### STAFF REPORT Roslyn Ridge West Project

**TO:** Kittitas County Hearing Examiner  
**FROM:** Bradley Gasawski, Staff Planner, Kittitas County Community Development Services  
**RE:** Roslyn Ridge West Planned Unit Development (PD-24-00001),  
Short Plat (SP-24-00004)

**HEARING DATE:** December 16, 2024 (Hearing Date)

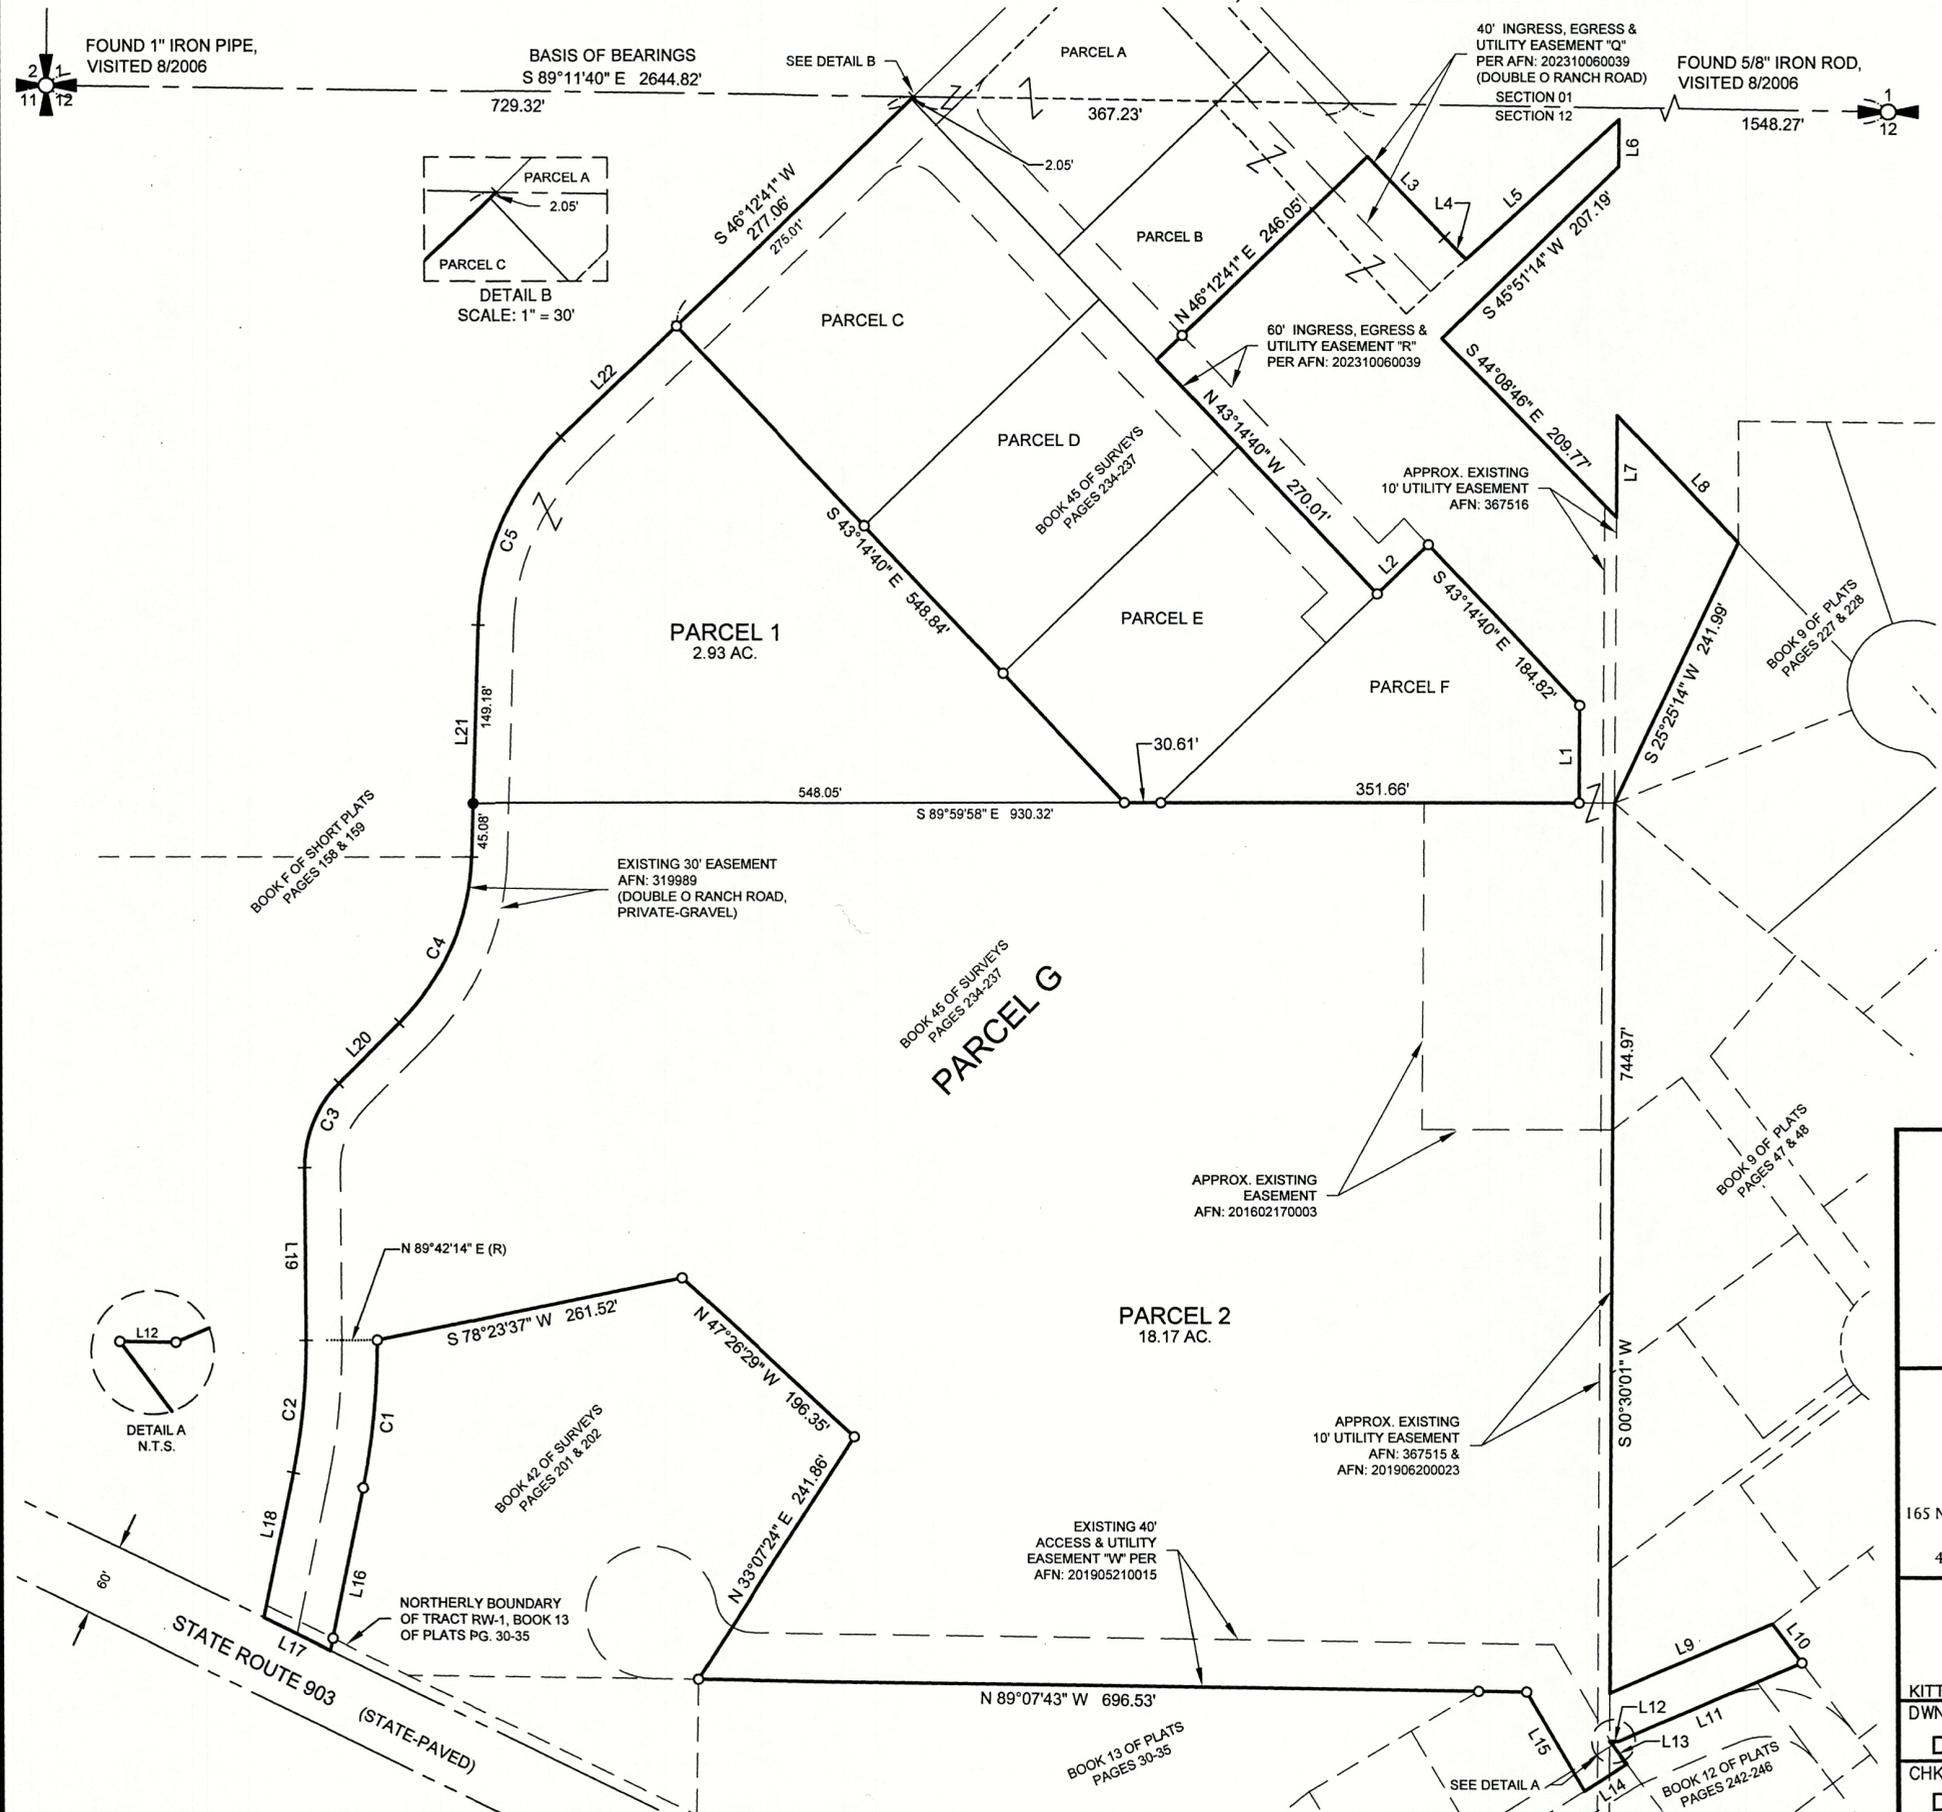
Due to item #1 listed below, this submittal has been reviewed as a prelim Short Plat only, and a complete review has not been performed.

1. The Short Plat will need to reflect revised boundary lines per BL-24-00012 already approved.

2. Parcel areas, legal description and reference documents will need to be updated to reflect the recorded BLA.
3. Revised title report and Lot closures will need to be provided at final.
